Re: Planning Application WA/89/18/L

With reference to the above planning application we wish to lodge our objection to the screen already in situ.

Drawing / Elevation
of replacement
Privacy Screen
above existing
dwarf Wall

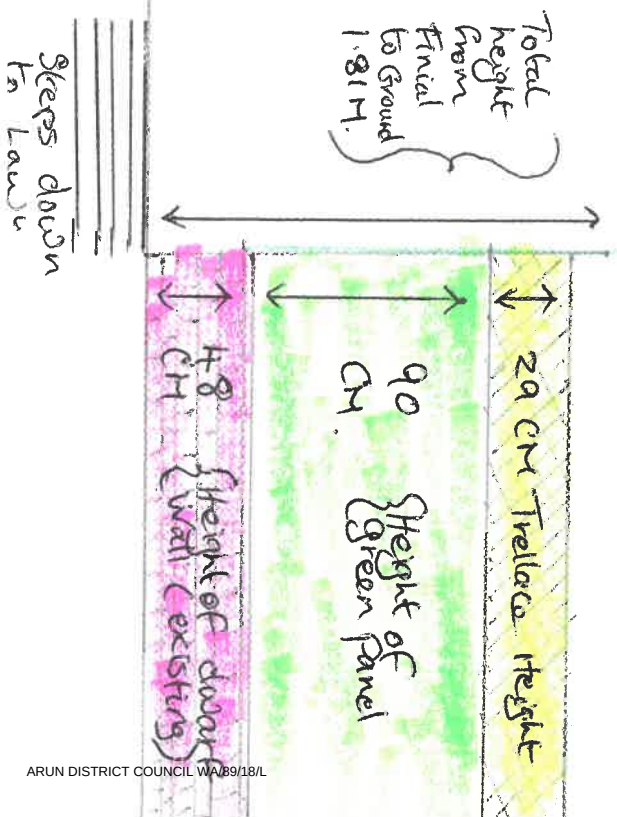
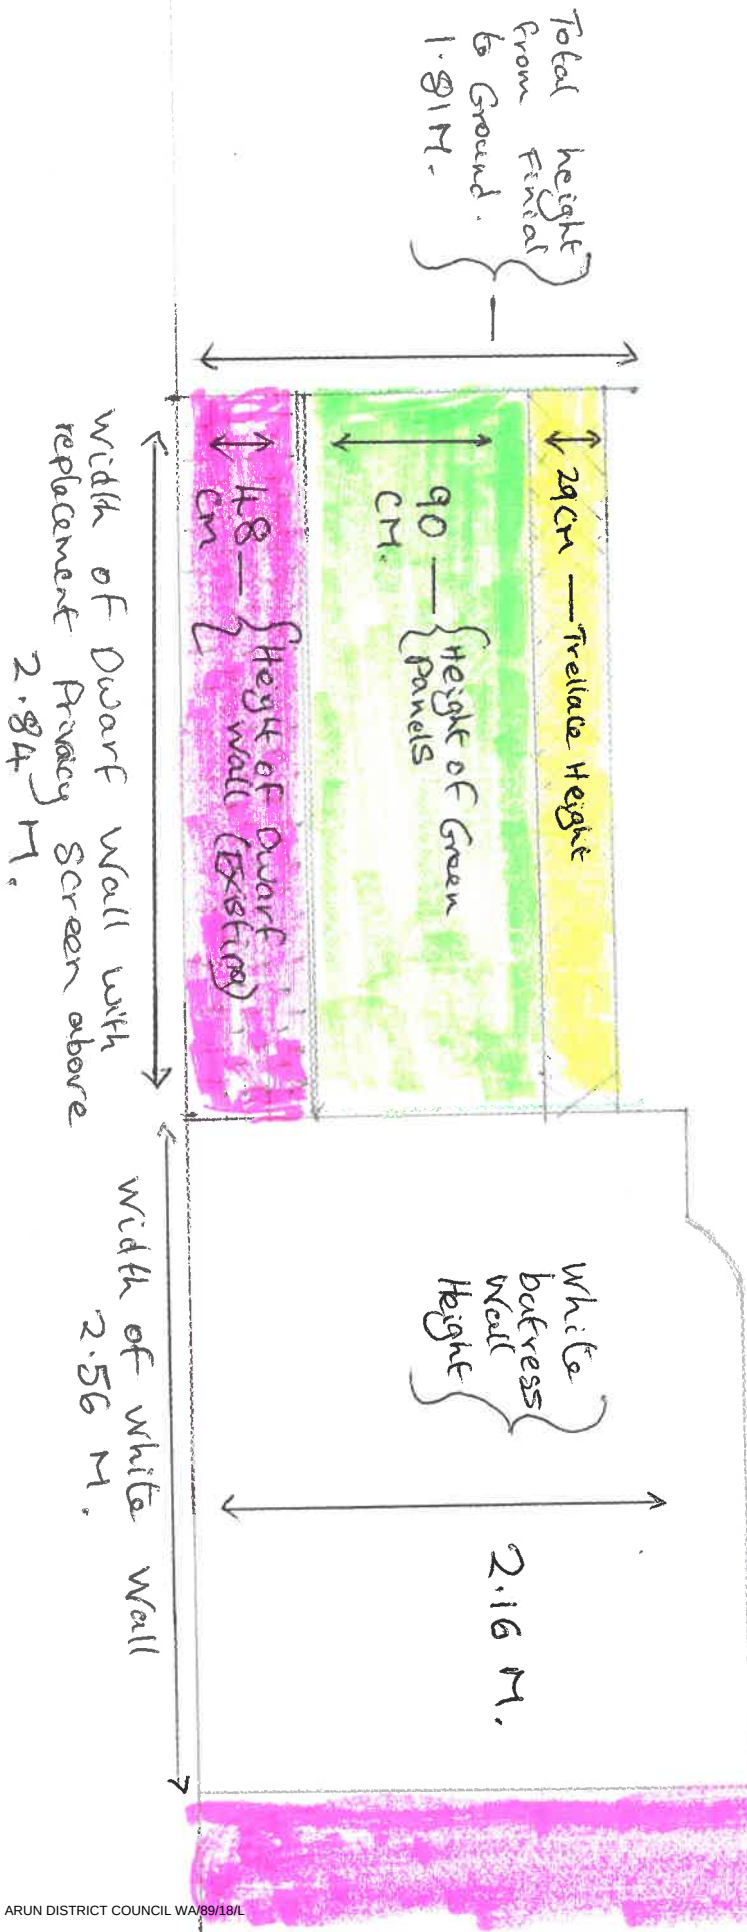
The screen does not sit well within a country house property of the Regency period, which includes Doric columns to the south side of the building.

We feel consideration should be given to the Grade II* classification of the building.
